Our ref: P01441661

18 October 2021

**LAND OFF FULLWOOD DRIVE, GOLCAR, HUDDERSFIELD, HD7 4DH
Application No. 2021/93621**

Historic England Advice

4 Front
1 : 100

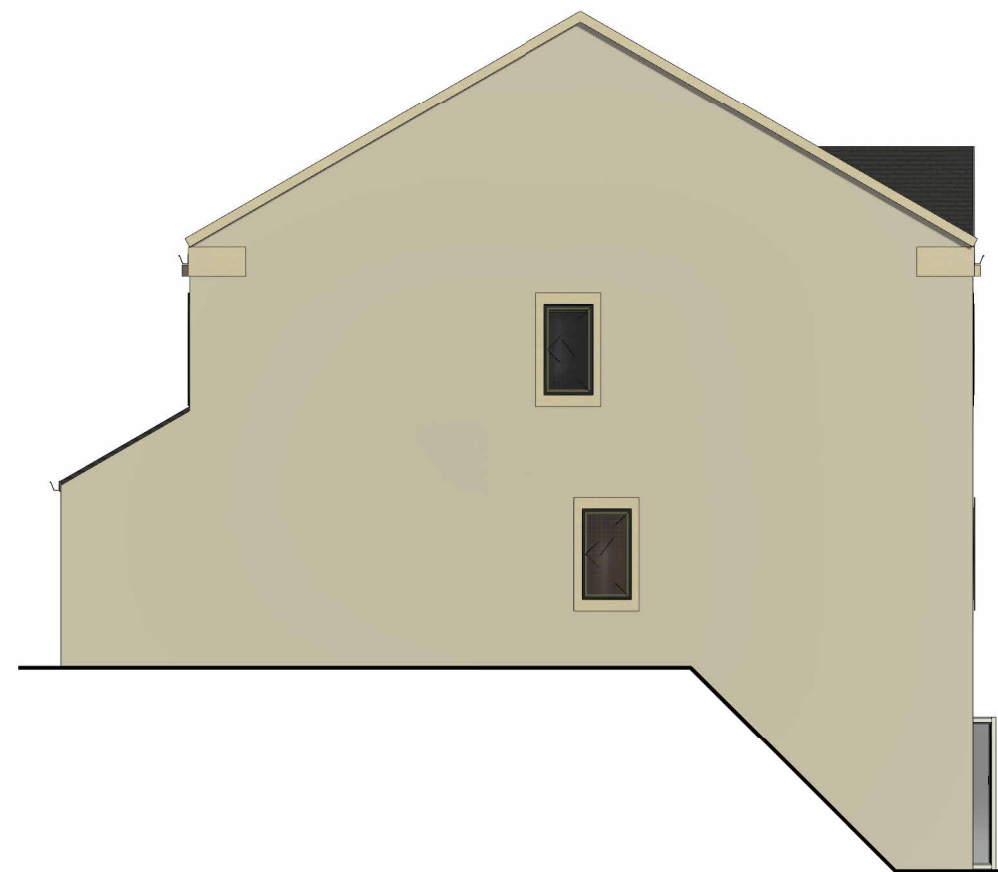
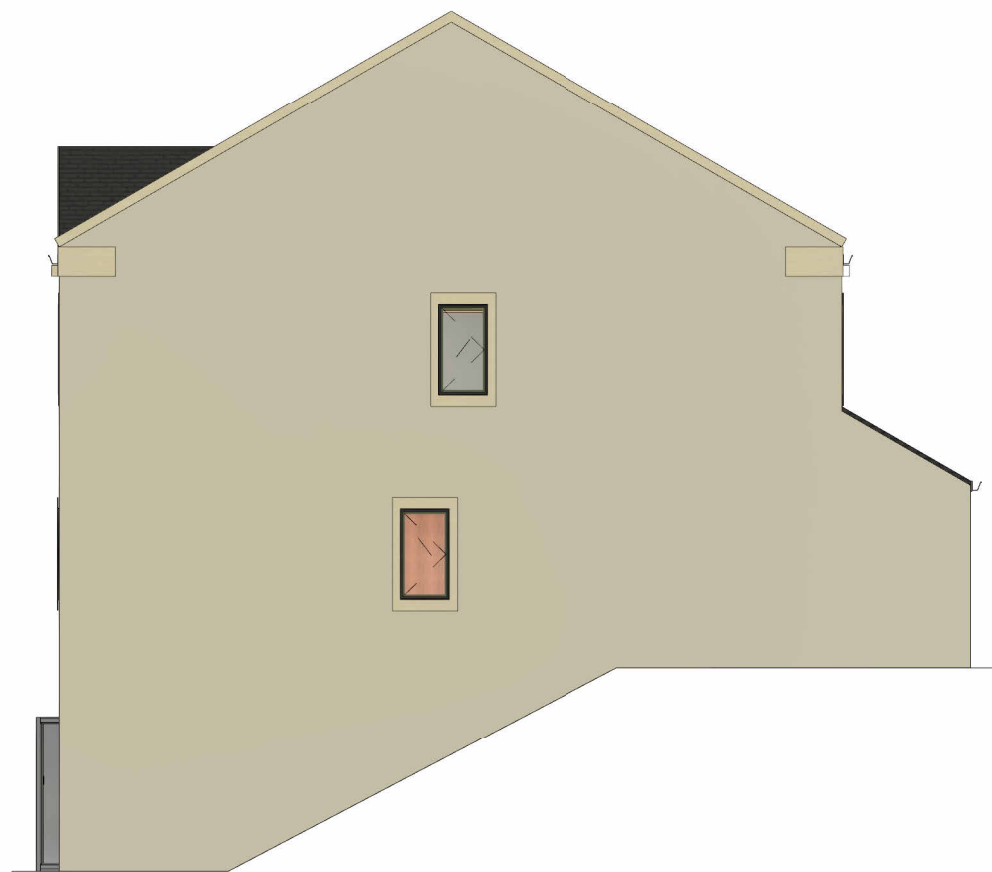
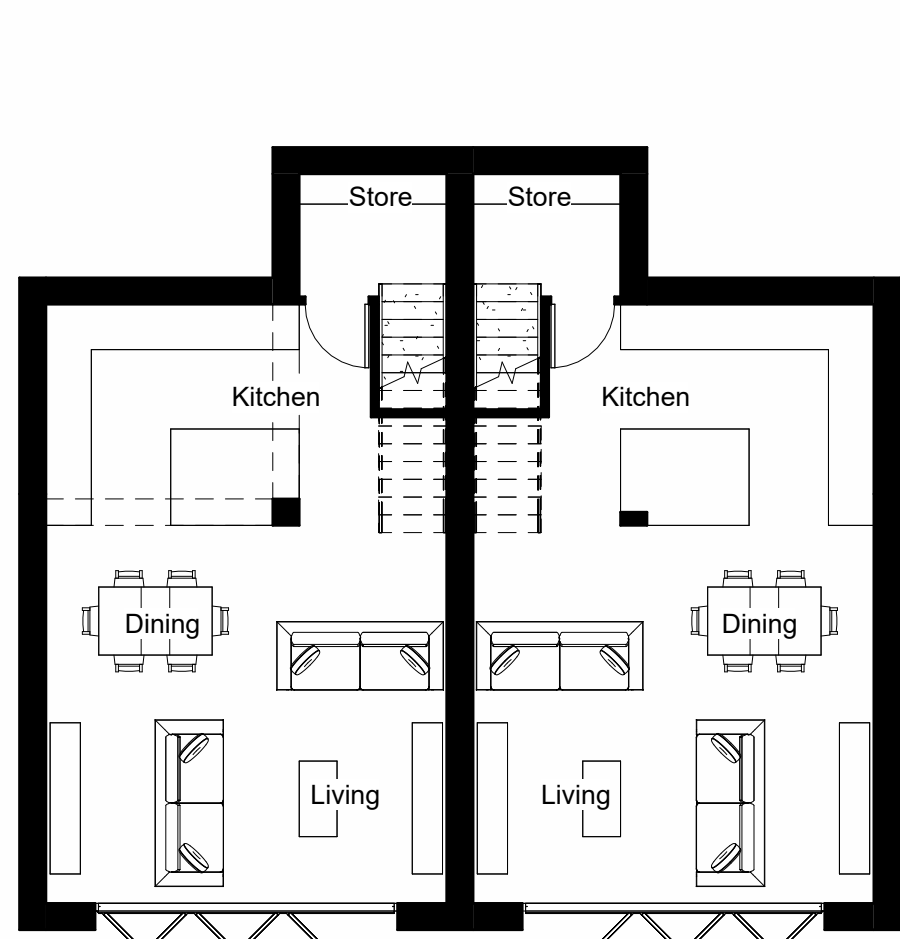
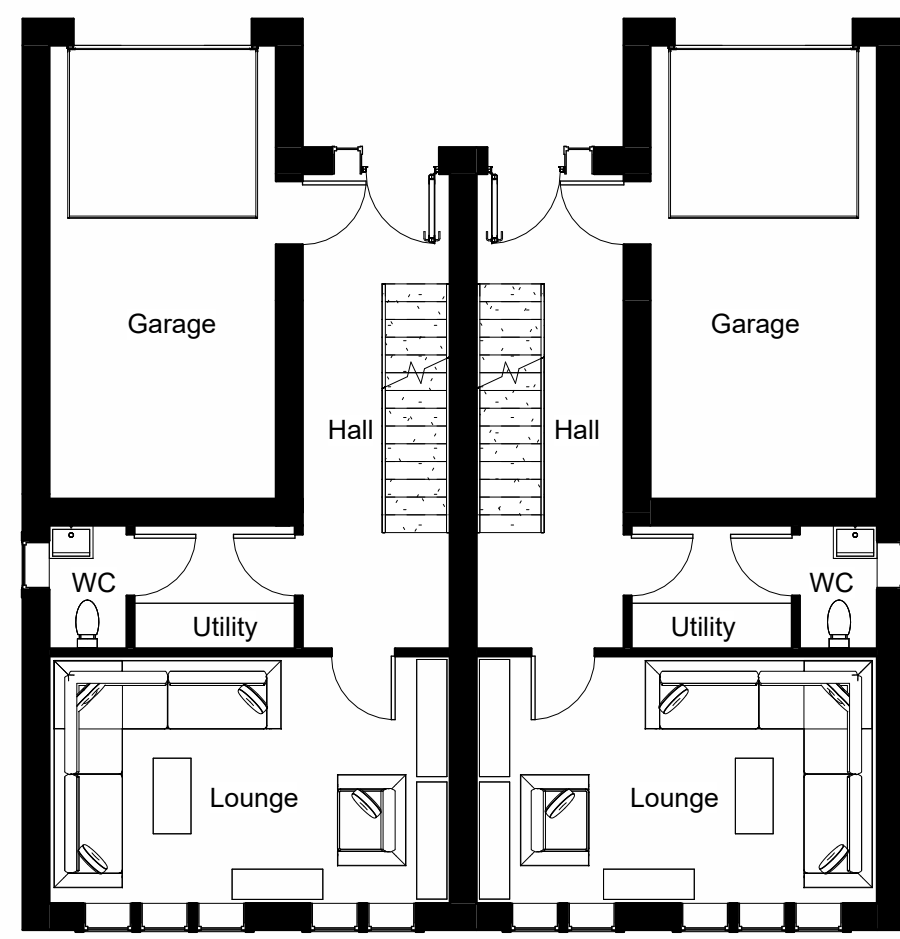
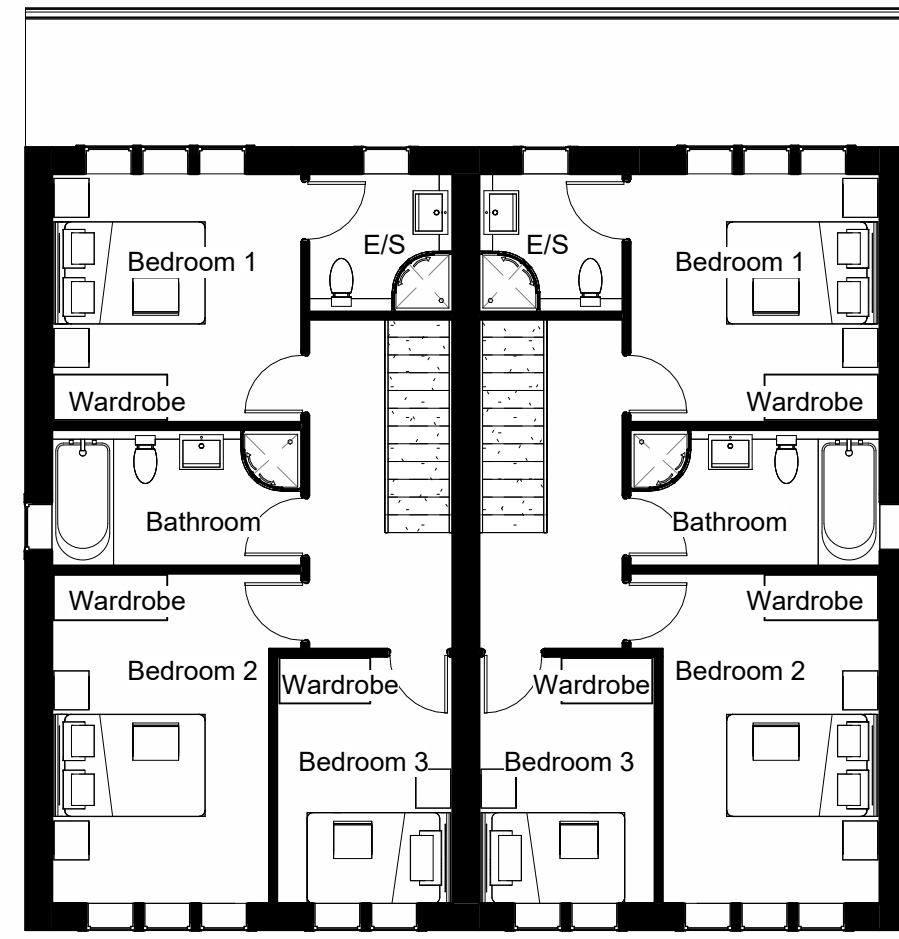
Windows to plots 1-5 take inspiration from the mullioned windows found on historic buildings within the conservation area. This approach has been used successfully on other modern developments within Golcar so we welcome this proposal. The proportions of the windows as shown do not look convincing and we would recommend the windows should be taller to have a greater vertical emphasis, particularly on the south elevation. The gable form is seen on some buildings within the area, but generally not in a repeated form as seen here with a similar gable on each of the five buildings. We recommend this feature is omitted or is included on a fewer number of the dwellings.

The south elevation of plots 6-10 is quite busy in comparison to the more modest style of buildings in the surrounding area. We recommend some of the elements, such as the gables, projecting bays and balconies are pared back to better reflect the character of the conservation area.

As with plots 1-5 we also recommend slight amendments to the proportions of the windows to have a more vertical emphasis.
